**Planning Department
Transportation Development Services**

January 20, 2015

**Re: A-Class Storage on 2nd Street, 5124 Second Street
Traffic Circulation Layout
Engineer's Stamp dated 01-13-15 (F15-D052B)**

HC PARKING DETAIL
NTS

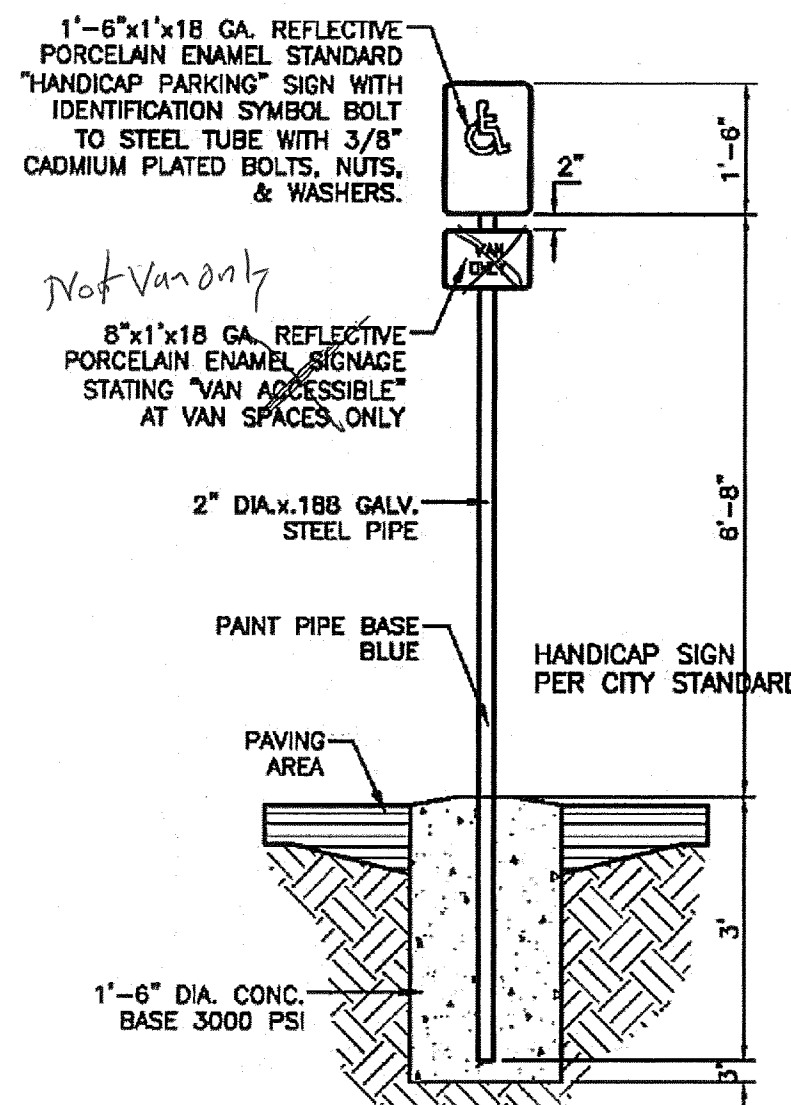
2. The ADA access aisle shall have the words "**NO PARKING**" in capital letters, each of which shall be at least one foot high and at least two inches wide, placed at the rear of the parking space so as to be close to where an adjacent vehicle's rear tire would be placed (66-1-4.1.B NMSA 1978). It is called out on a note for the "HC Parking Detail", but to be clear, also label these words on the actual van aisle.

3. For better clarity on the "Violators are subject to towing" signage, include the correct spelling of "Violators" and since it has a star by it, include the corresponding star on the actual sign detail to point it out this language a little better. (Otherwise, just show the added signage to the detail of the sign shown on the plan.)

- section. For the existing common access driveway onto the 36-foot wide private access easement road to the south, call out for it to "Remain."
6. For better clarity on the "HC Parking Detail", for the sidewalk call-out note, call out "6" high, 6-foot wide turnaround sidewalk".
7. Please resubmit 2 copies of the Traffic Circulation Layout for the next submittal. Resubmit acceptable package along with fully completed Drainage Transportation Information Sheet to front counter personnel for log in and evaluation by Transportation. Please feel free to e-mail a pdf version for my quick review prior to the next hard copy submittal. If you have any questions, please contact me at (505) 924-3924.

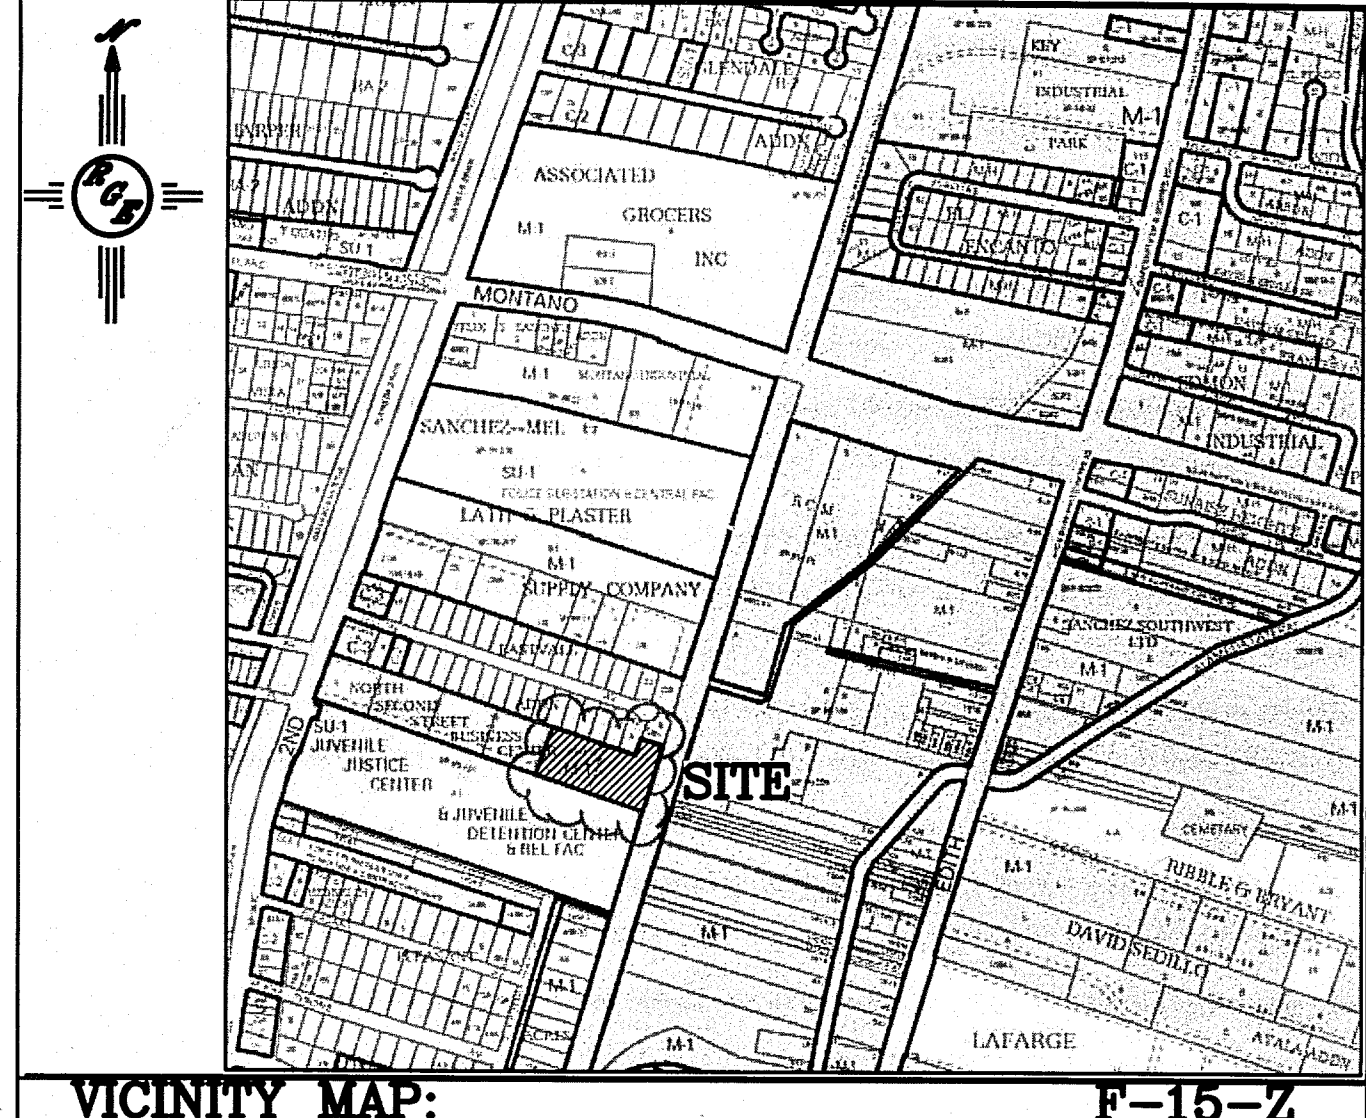
1. Show both the north and south limit of the 34-foot motorized gate at the site entrance. (This could be achieved with a dimension line to clarify exact location.)

4. The motorcycle parking interferes with the sight distance triangle shown for the 24-foot access easement. The motorcycle parking will need to be relocated.

5. Show the existing pavement edges for the 24-foot wide common access easement, and indicate all limits of the 3-inch asphalt removal and replacement within this 24-foot wide common access easement. Be sure not to encroach this asphalt replacement into the neighboring property by indicating all north, south, east, and west boundaries of the 3-inch asphalt pavement removal and replacement. Also, call out subgrade preparation for the 3-inch asphalt thick
